**Consultation Response from KC,
Highways Development Management**

2024/92031 Headlands Works, Headlands Road, Liversedge, WF15 7NT

Outline application for erection of residential development, adoptable road and public open space

Date Responded: 28-10-2025.

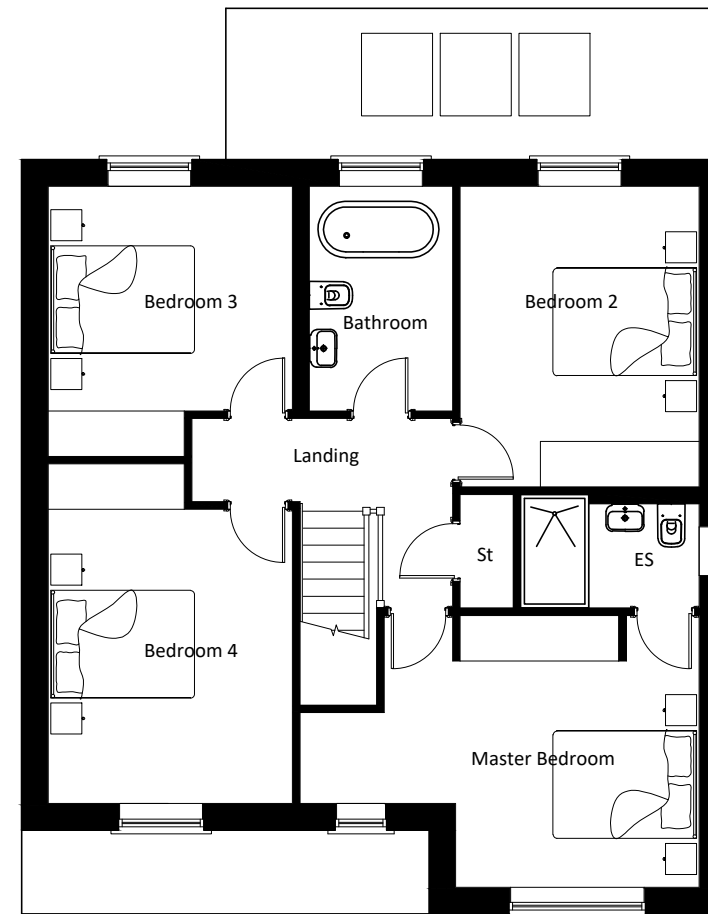
2, The garage to house type A (4 bedroomed) needs to be confirmed at 6 x 3m to be counted as a parking space.

Title: **Existing & Proposed Long Sections**

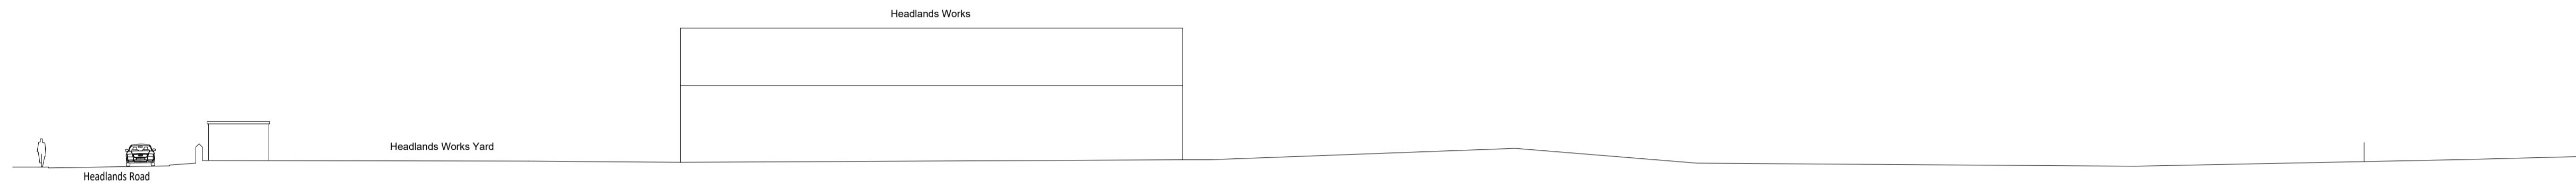
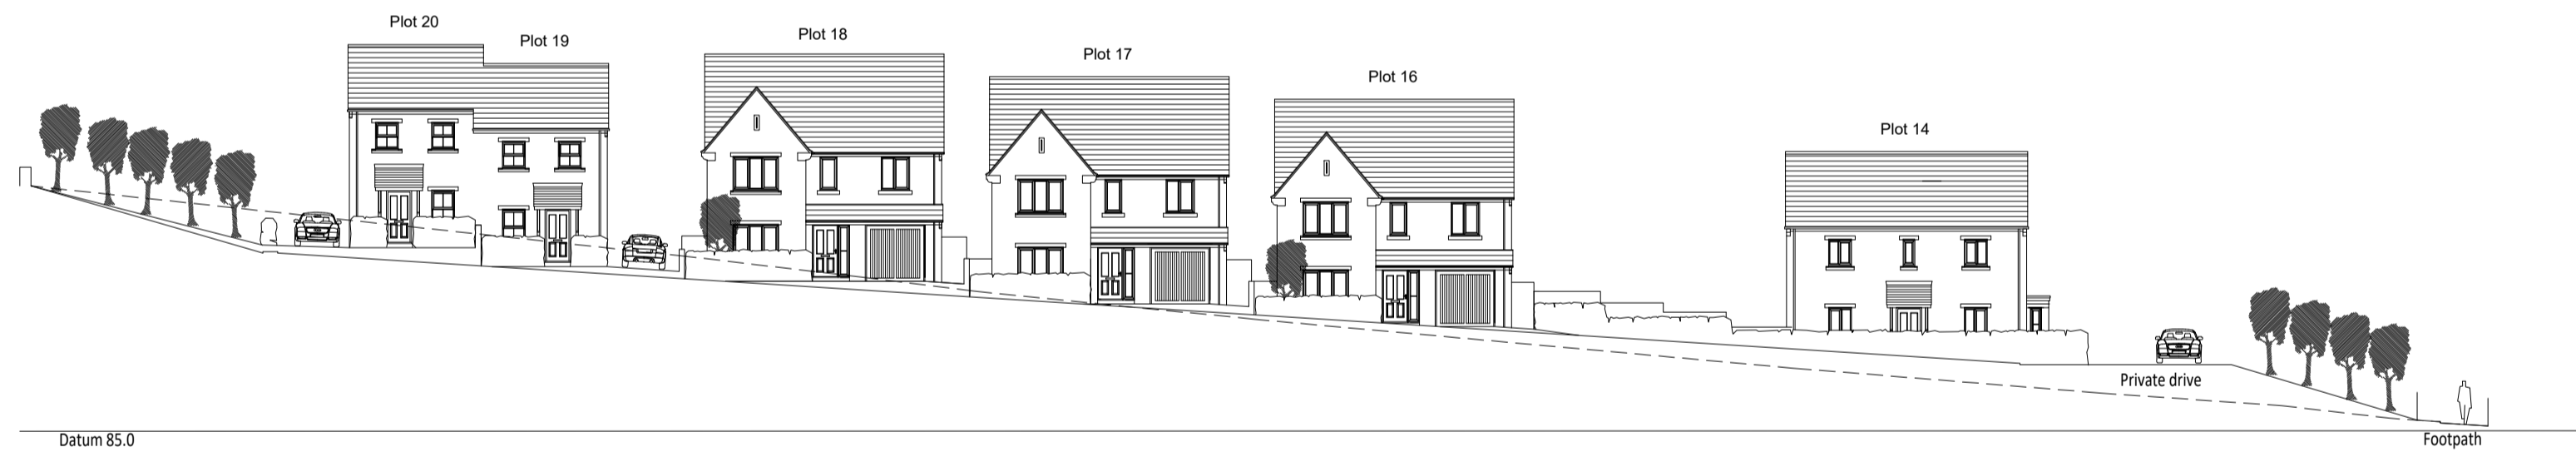
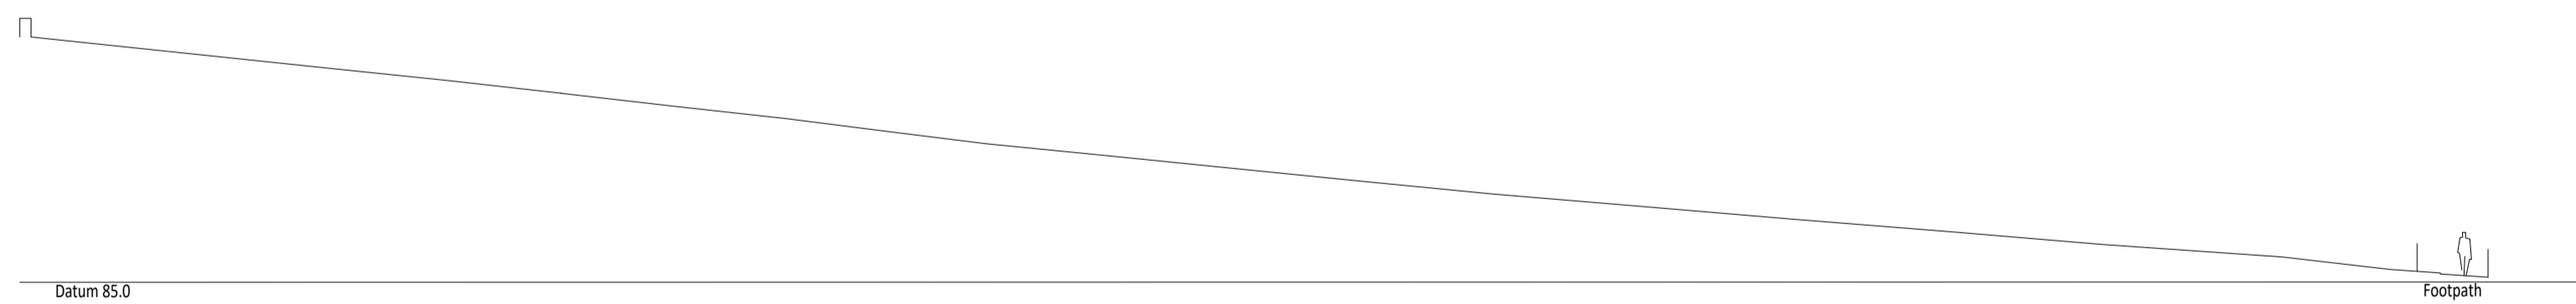
The carriageways that have a straight alignment will require vertical or horizontal deflection traffic calming at regular intervals in accordance with Table 1 above. Where horizontal traffic calming is proposed please ensure build outs are provided on either side of the carriageway to create a chicane as due to low traffic volumes single build outs or ones spaced some distance apart are not effective in slowing vehicles. Where vertical traffic calming is provided, please use a flat top road hump 4m wide at the top using our ramp from the standard details to ensure the vehicles do not ground out. Please note rumble strips are not accepted as they generate noise complaints from residents. Please note the alignment on the southern road is not considered sufficient to slow vehicles to 20mph and

therefore traffic calming as above will be required.

A long section has not been provided and will be required to ensure compliance with the Equalities Act 2010 where necessary. This must include details of the vertical alignment to determine appropriate carriageway and footway gradients. Shared surface carriageways will need to be Equalities Act 2010 (DDA) and Kirklees Design Guide compliant and be no steeper than a maximum of 1:21 or 5%. If the carriageway is steeper than 5% then a Local Residential Street (Type B) with footways both sides would be required as per Table 1.
